**KIRKLEES METROPOLITAN COUNCIL
INVESTMENT & REGENERATION SERVICE**

DELEGATED DECISION TO DETERMINE PLANNING APPLICATIONS

Reference No: 2020/62/93637/E

Description: Demolition of clubhouse and erection of detached dwelling with associated external works

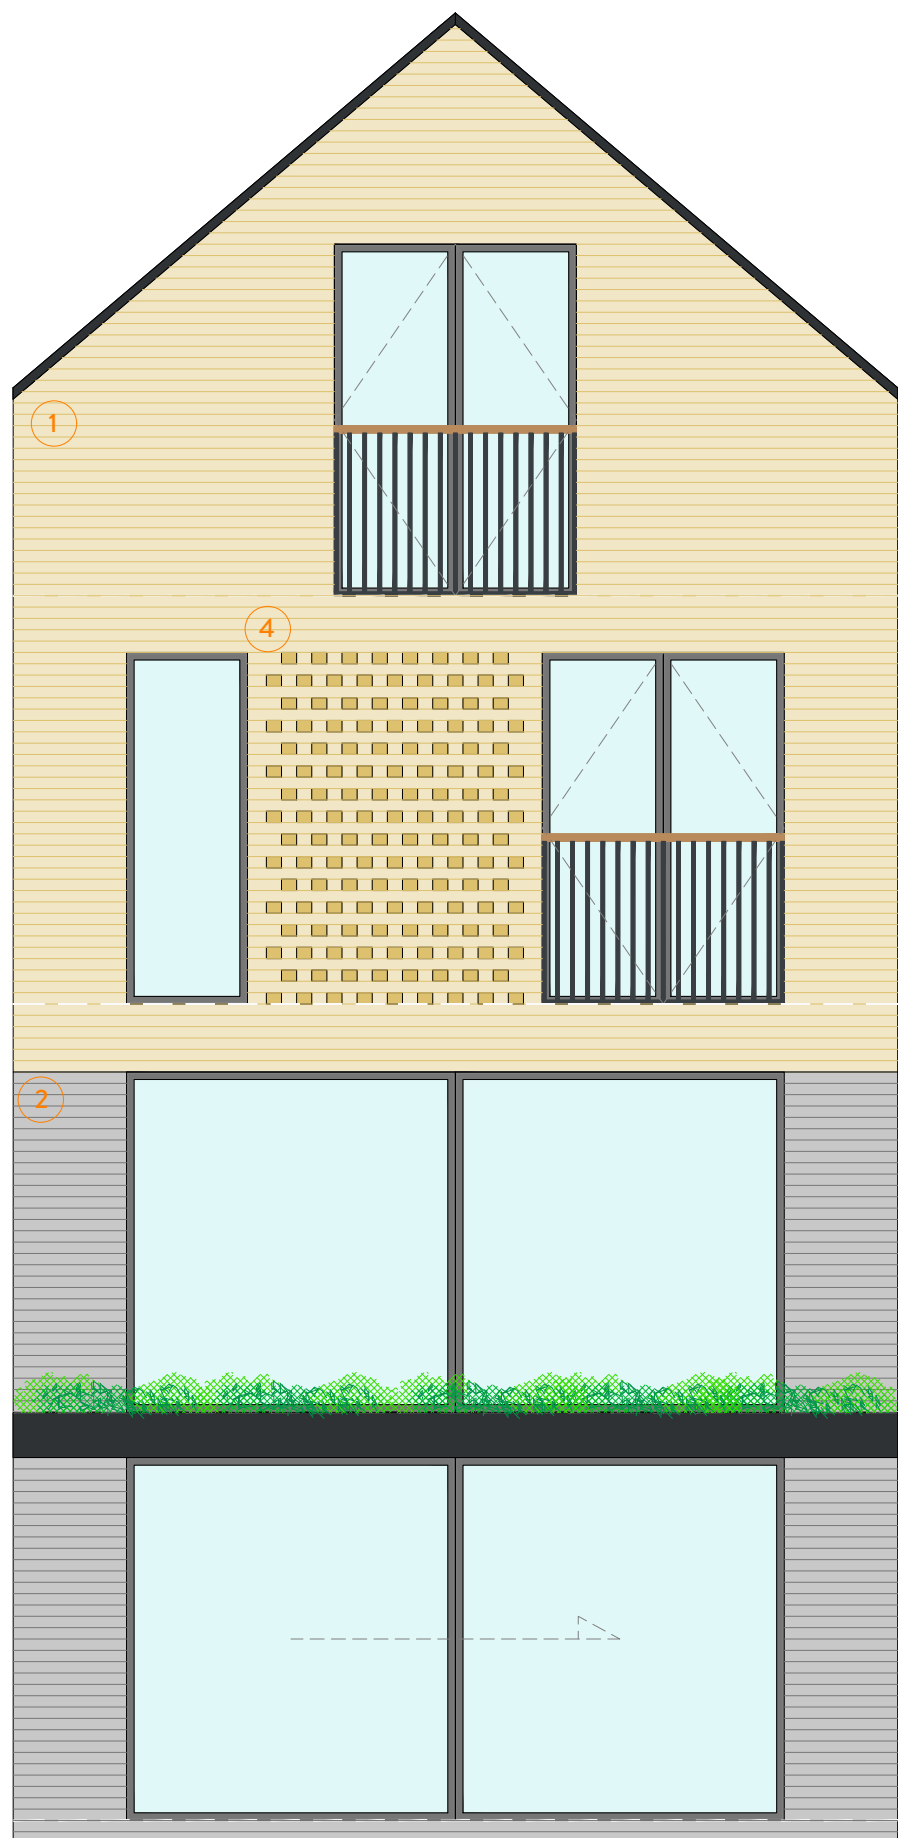
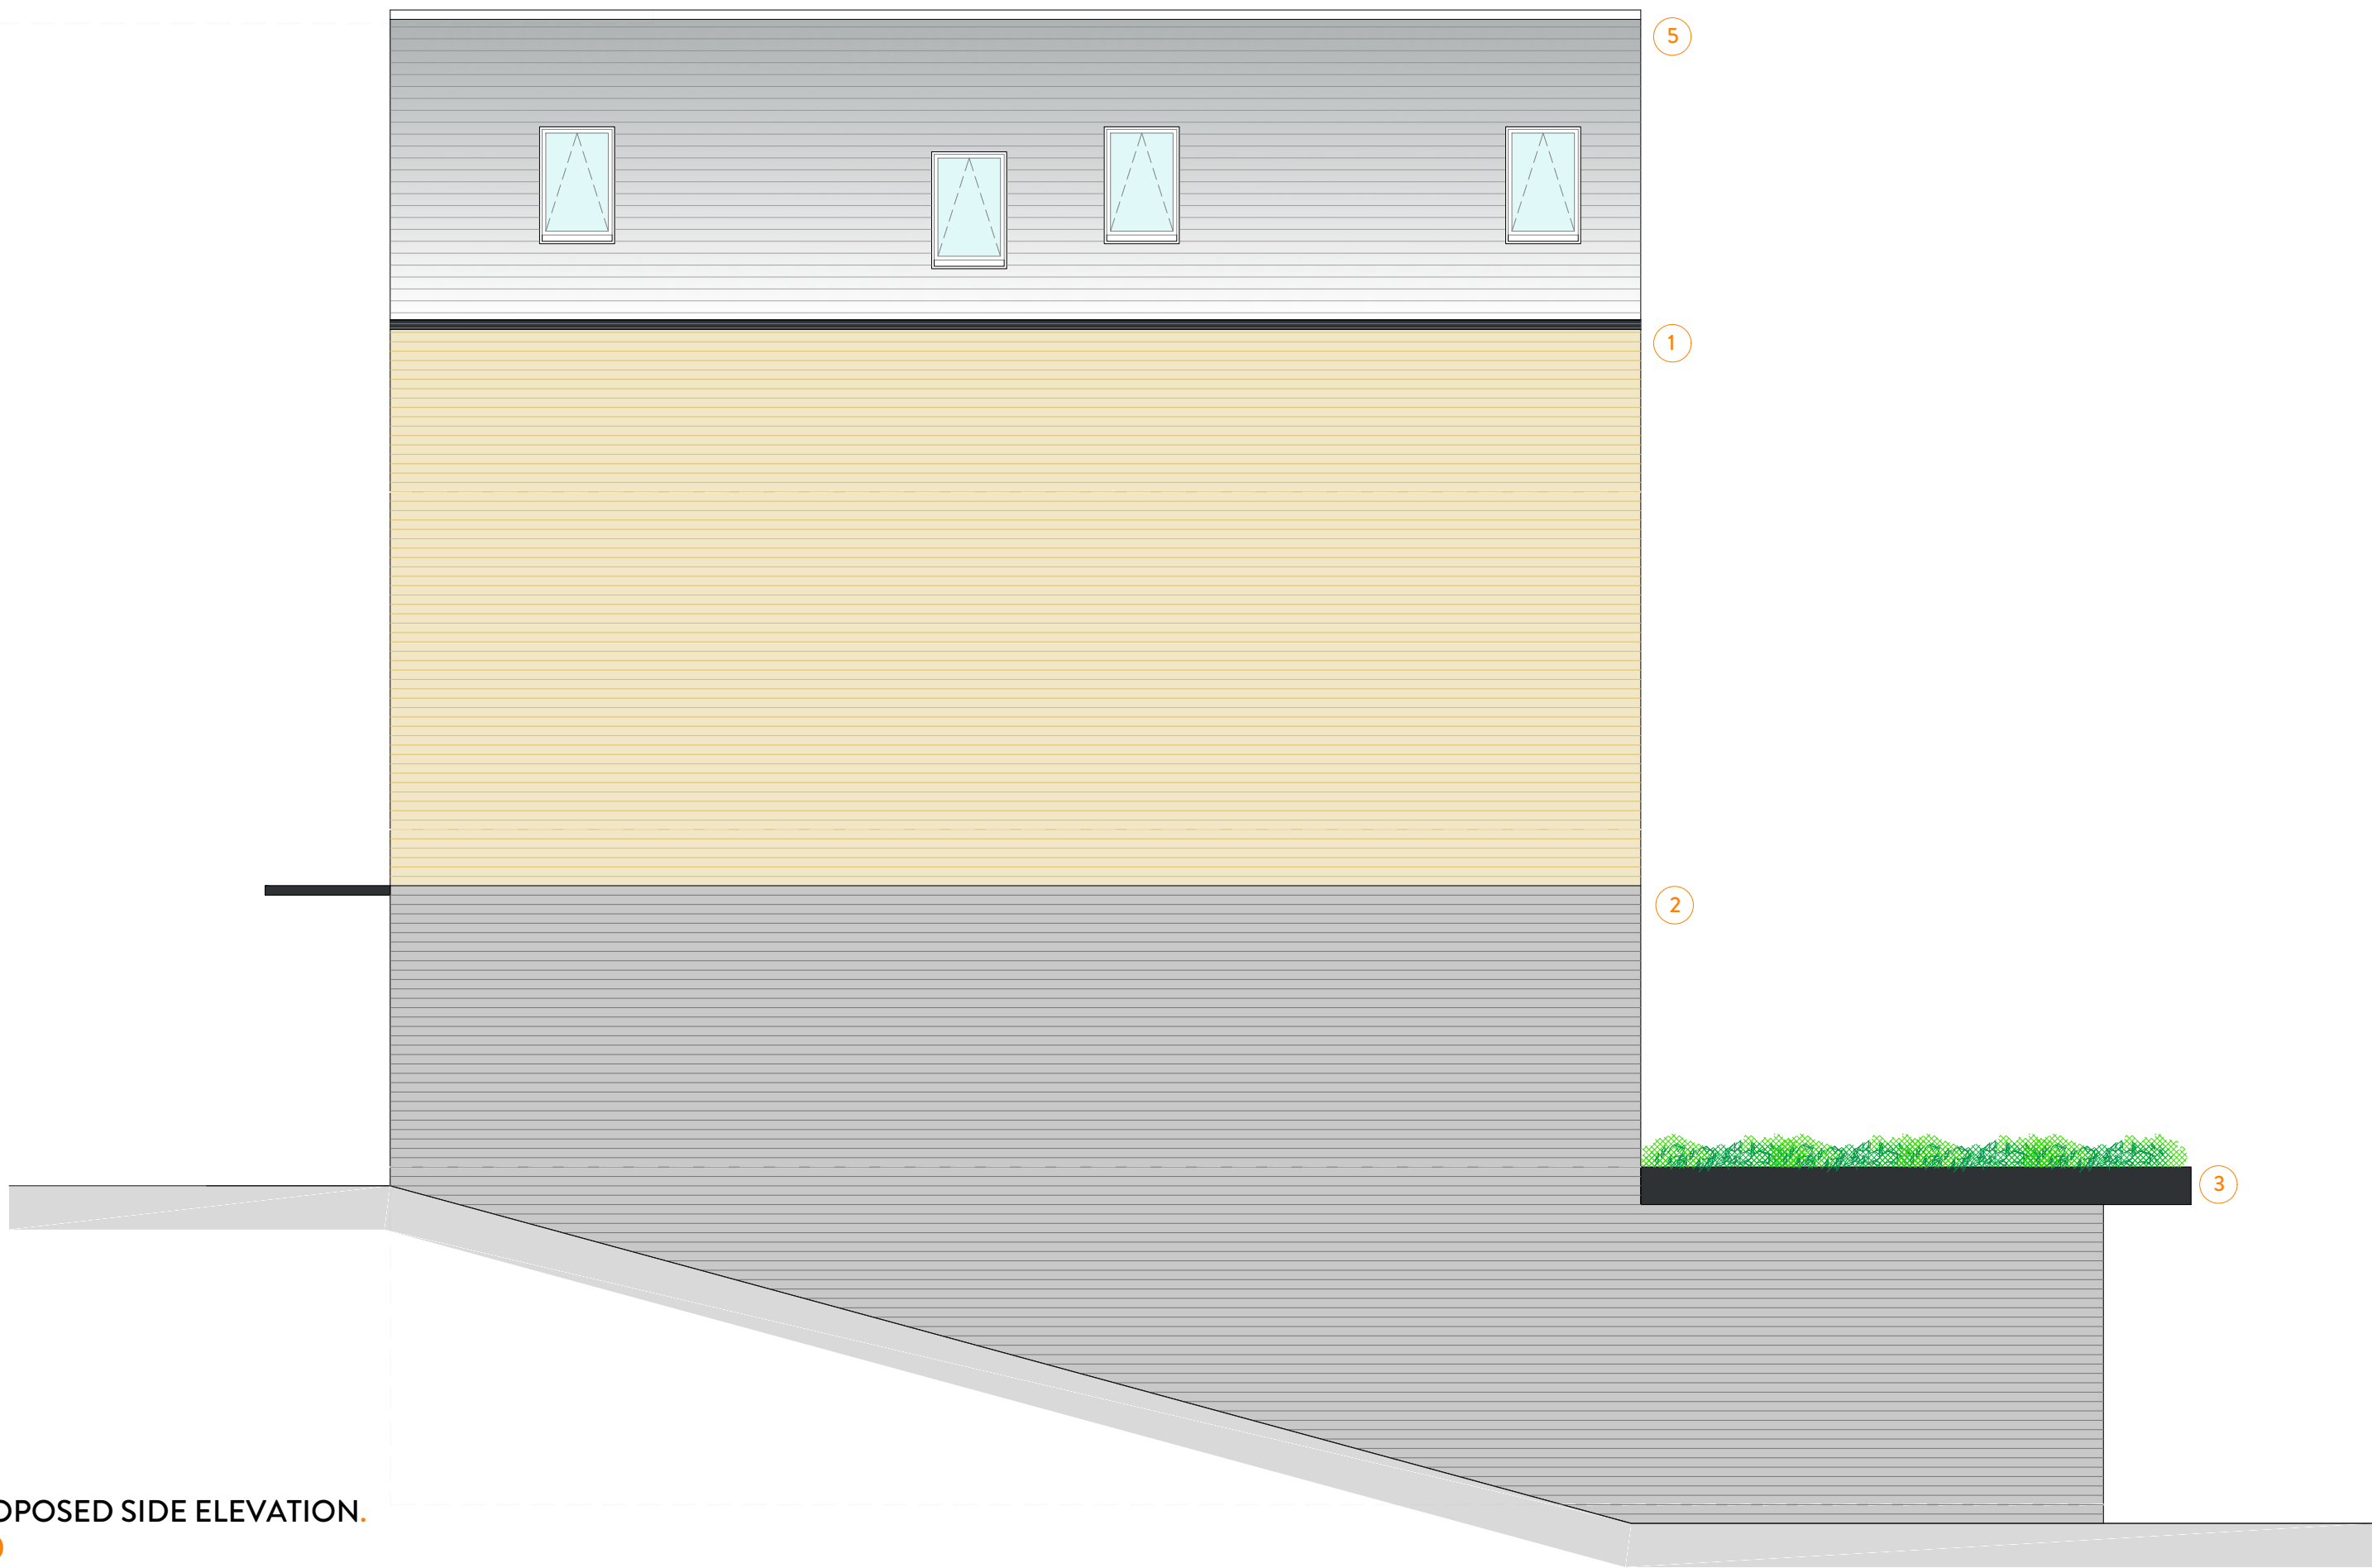
The principal elevations of the dwelling would be located to the front and rear (north-east and south-west) with an area of private amenity space to the rear. Through the course of the application, the applicant was asked to omit a terrace to the western elevation of the dwelling, to prevent a loss of privacy to the adjacent property No.41/43 Stocks Bank Road.

The rear back-to-back properties adjacent to the site would be completely overlooked

is available onto this. A small terrace to the western elevation of the building was removed through the course of the application.

Response: No windows are proposed to the western elevation of the development and, as such, no overlooking would occur to these properties.

3. The external facing and roofing materials of the development hereby approved shall accord with the details included on plan refs (30)001 REV B and (30)002 REV B, and shall thereafter be retained.
